From: Simon Davis
Sent: 31 July 2019 11:25
To: Rebecca Redford [REDACTED]
Subject: Y/61/19/PL - Yapton Metal Company

I have identified a couple of issues with the plans (the elevations when compared to the block plan) and these need to be fixed:

Site Plan (Proposed) 1:200

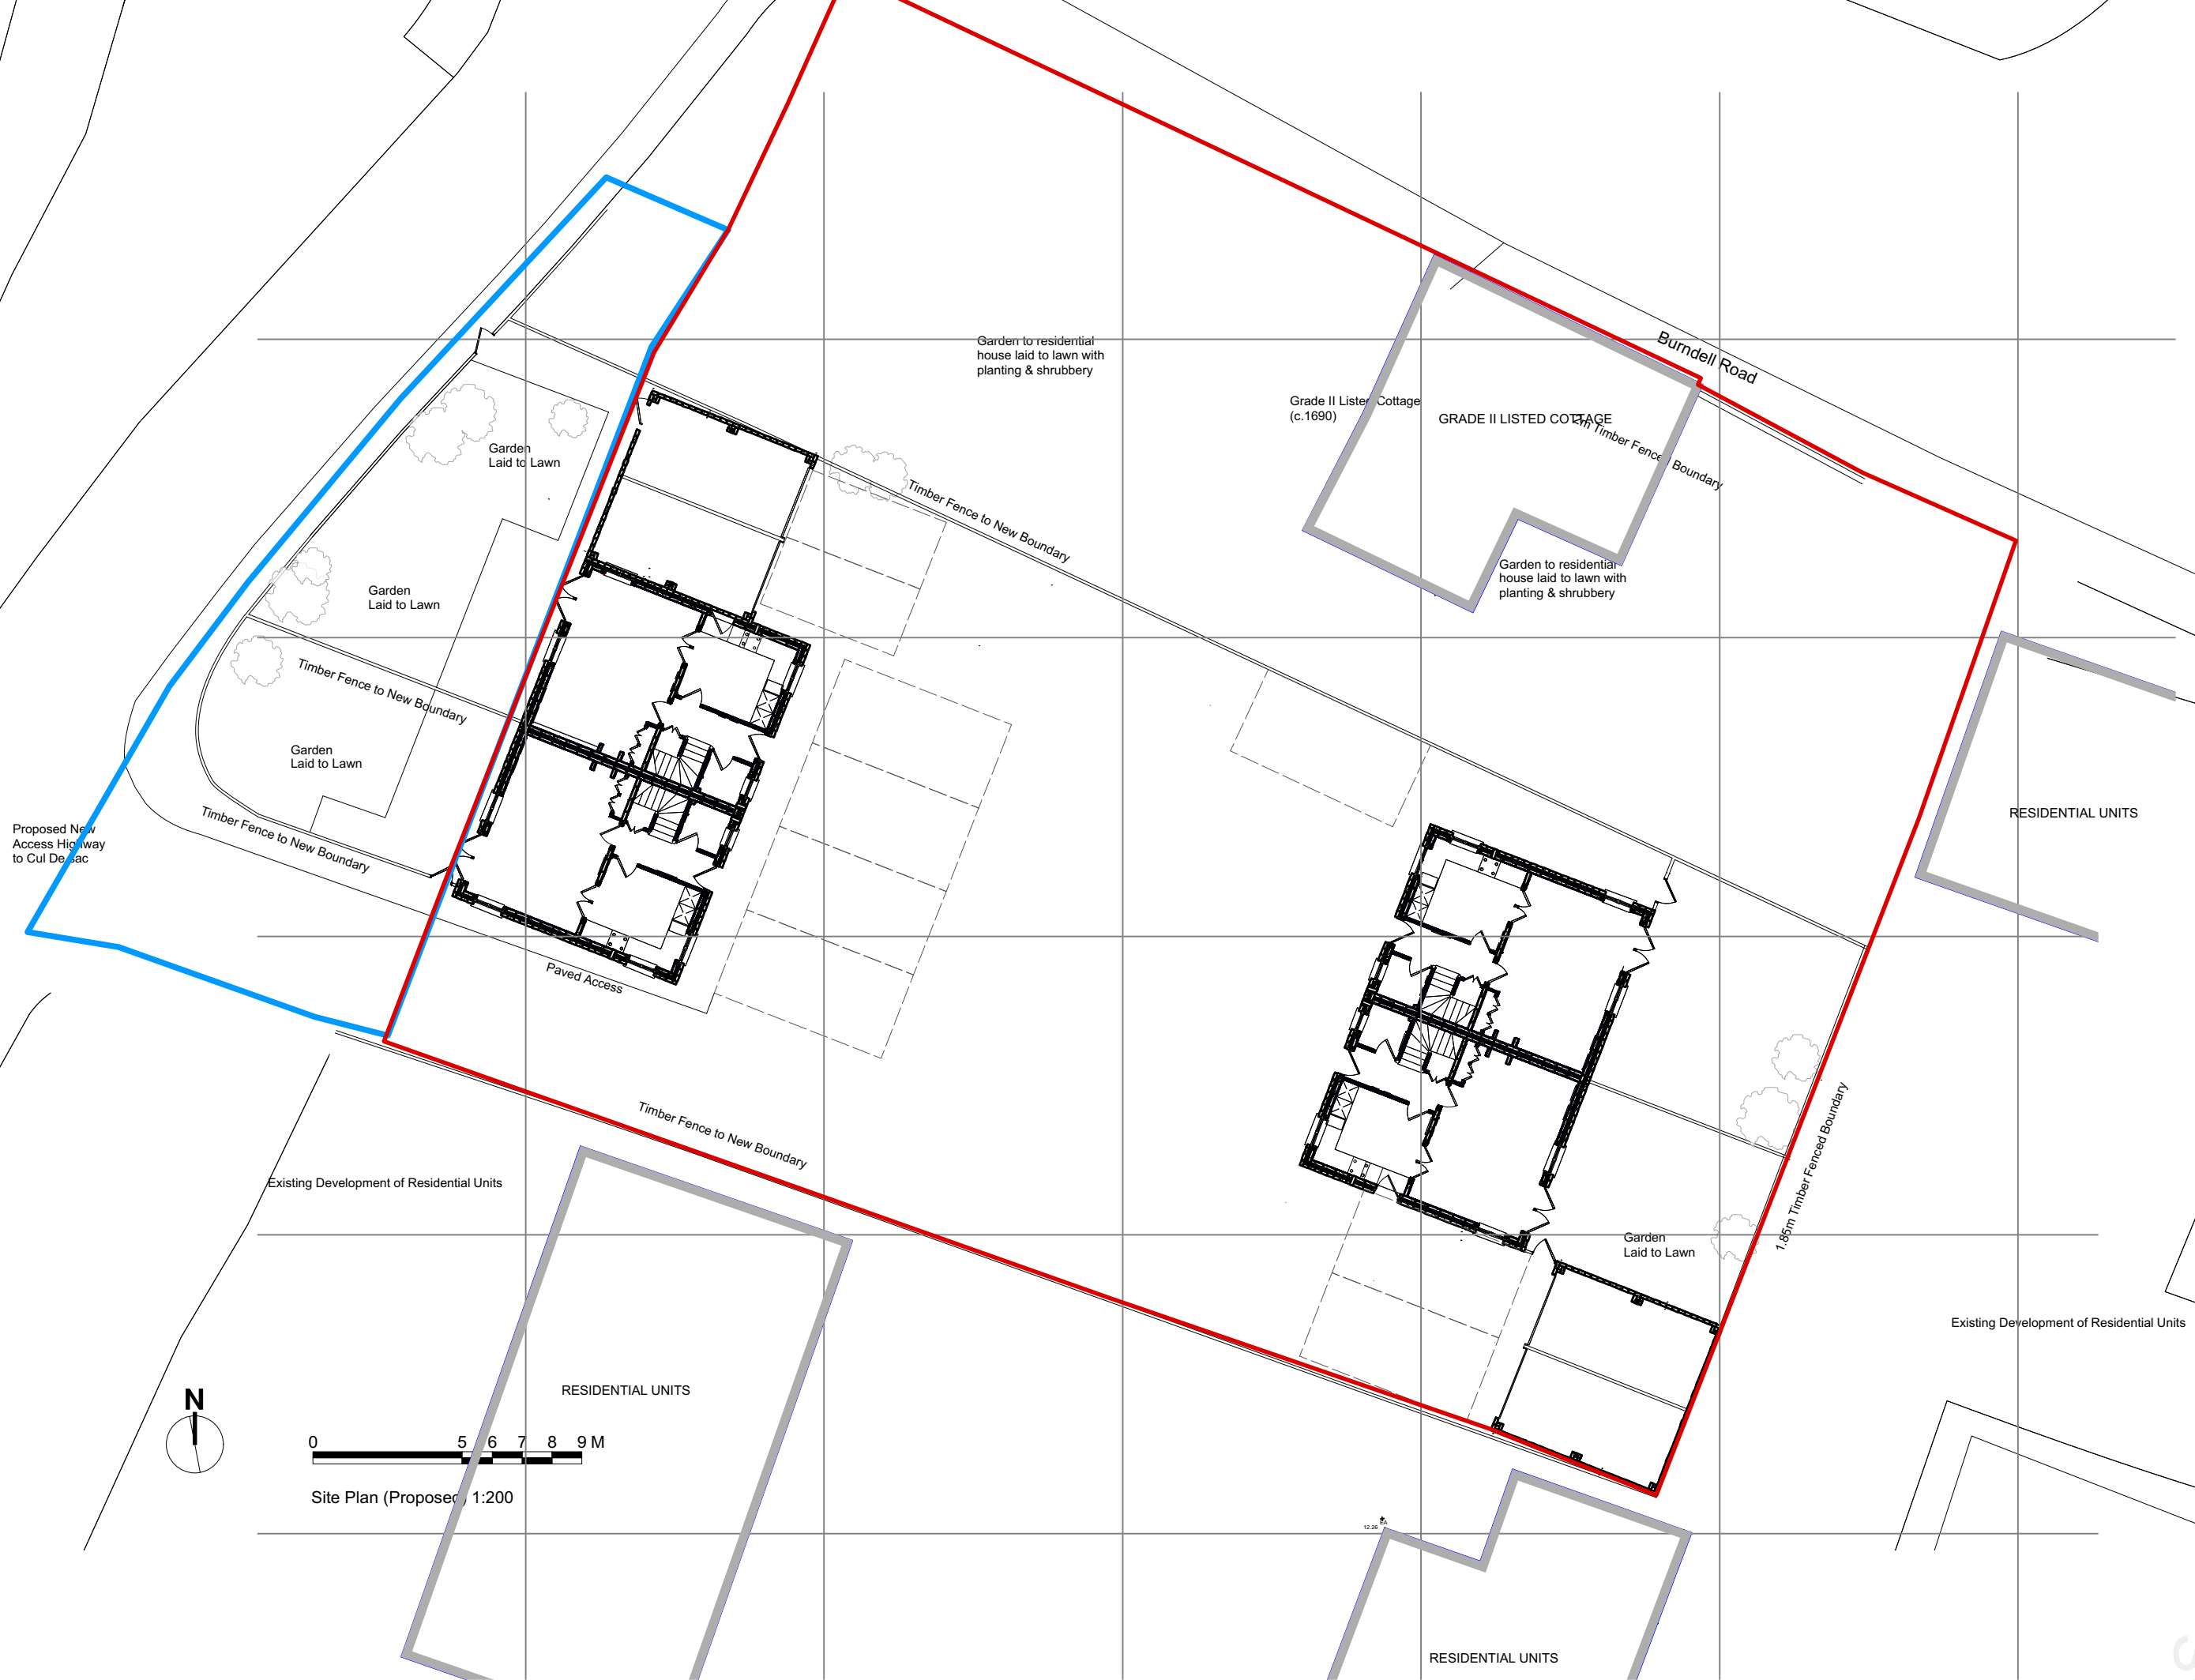
- Unit 3 has no bins shown on the block plan
- The unit 1 elevations are missing a GF kitchen window on the east elevation
- Unit 3 has a window shown on the GF south elevation where the block plan indicates a door.

I would also like to take this opportunity to request that you change the rear garden fencing to hedging for units 1 & 2. I understand that full height hedges can be purchased.
